From: Marc Fulker <[REDACTED]>
Sent: 15 July 2015 15:06
To: Daun Johnson
Subject: Re: LU/224/15/PDH

PROPOSED FLOOR PLAN AND
ELEVATIONS

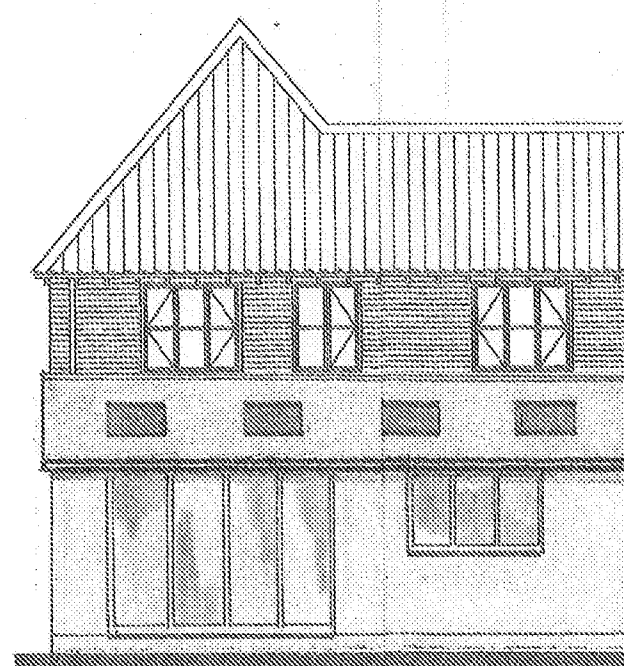
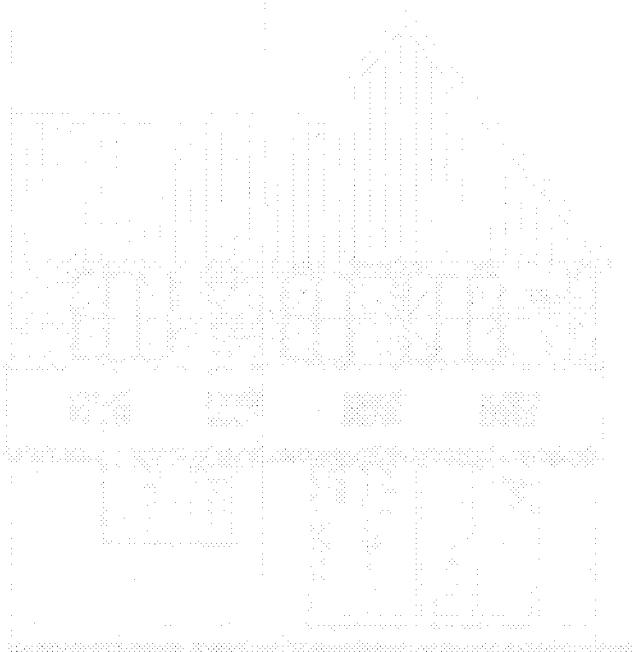
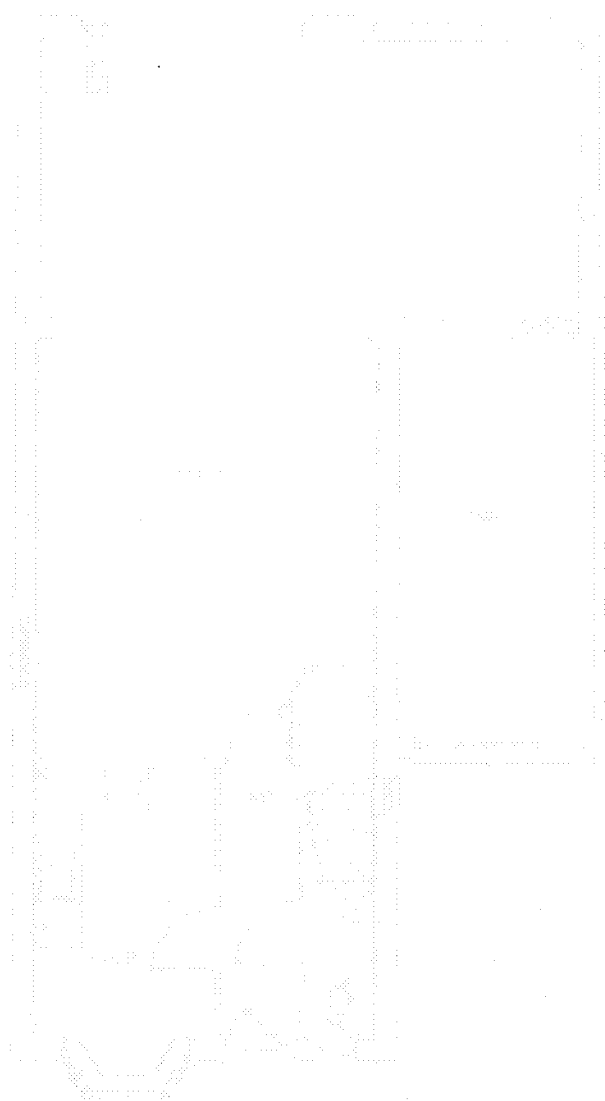
Please confirm that the eaves height of the proposed extension does not exceed the height of any part of the existing eaves.

Daun. In reply to your email I can confirm the eavea of the proposed extension will not exceed the height of the eaves of the existing building.
